**Sancrox Quarry Expansion Project (SSD-7293)
EIS Exhibition**

Simon Francis
Senior Project Officer, Assessments
Water – Strategic Relations
10 February 2020

Sancrox Quarry Expansion Project (SSD-7293) EIS Exhibition

Figure 6: Location of Monitoring Bore Holes
Source: Google Earth

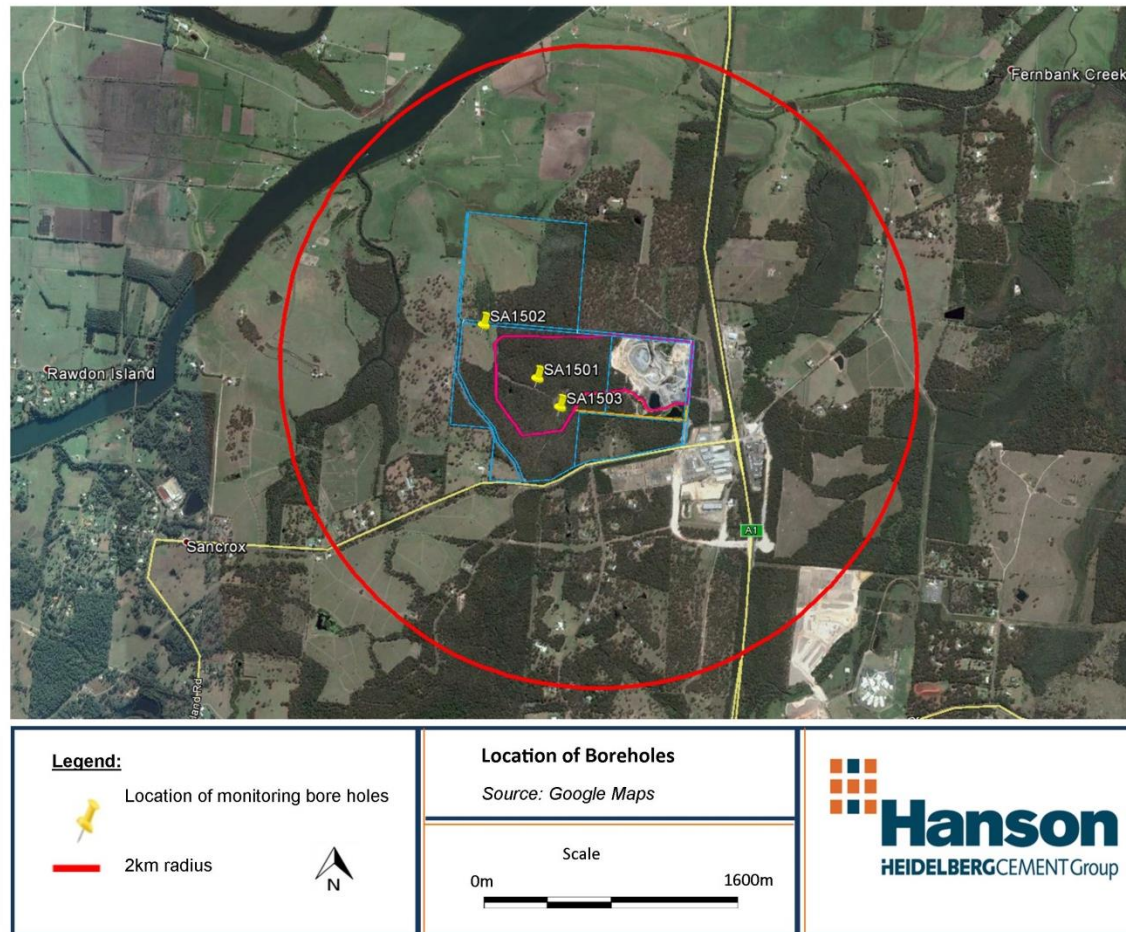
There are currently three groundwater monitoring bores within the proponents lease area and a further 13 bores within a 2 km radius of the pit. Two years of water level data were collected in the three monitoring bores at 12 hr intervals between October 2015 and July 2017. Water quality monitoring was completed only once during the pump test completed in November 2017 – this is insufficient to represent baseline conditions.

A water monitoring plan will need to be developed in consultation with DPIE Water.
